Our Ref: **AW/120/12/**
Your Ref:

Town & Country Planning Act 1990 (as amended)
Town and Country Planning (Development Management Procedure) (England) Order 2010
Application for Planning Permission

Development Installation of 1 no. new condenser unit
Location Barclays Bank Plc 6 Nyetimber Lane Bognor Regis

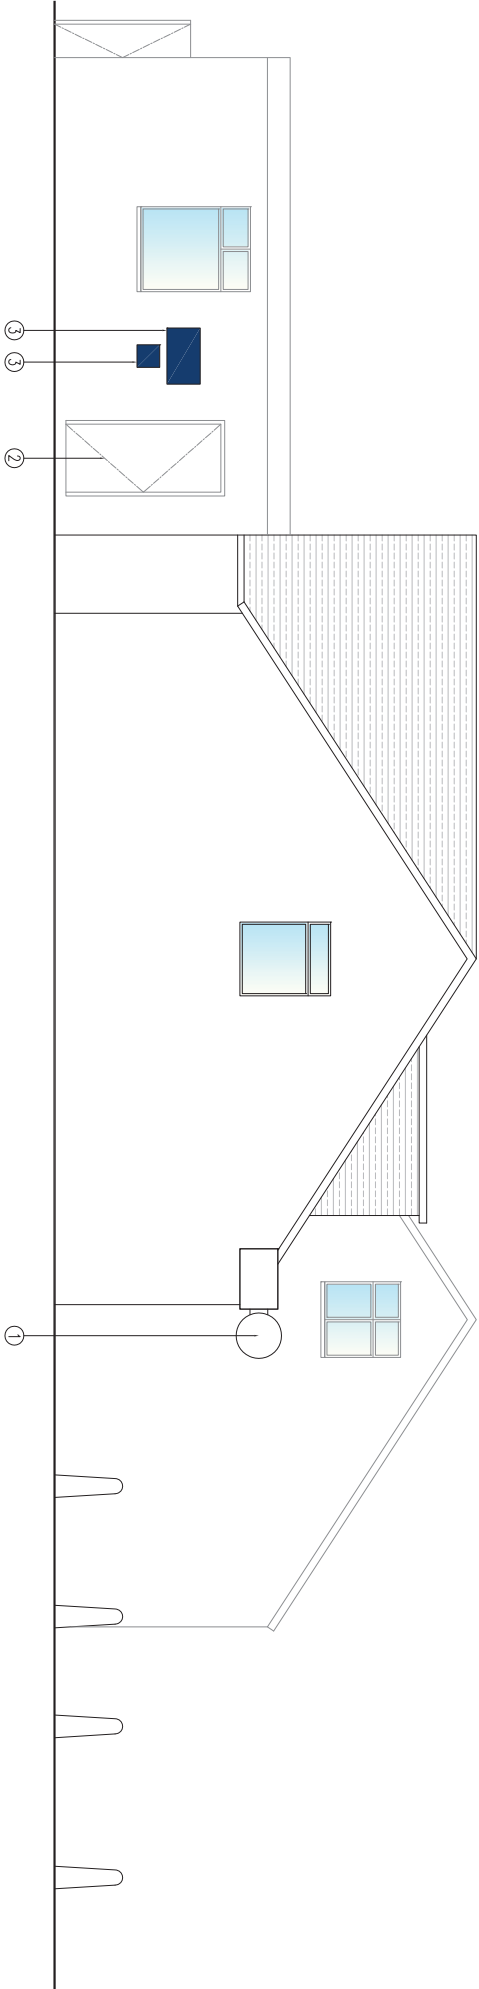
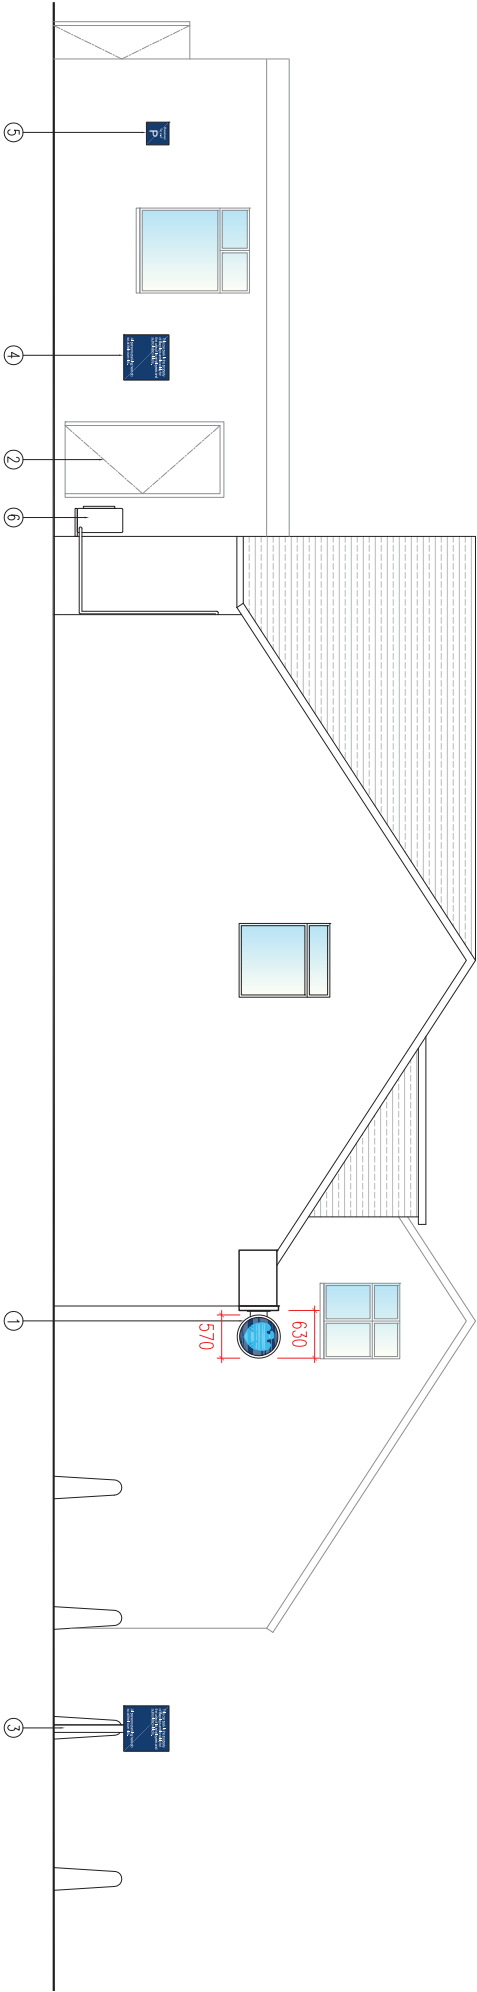
The existing and proposed side elevations show a window which is not shown on the existing and proposed floor plans. Please provide 1 electronic or 3 paper copies of revised plans.
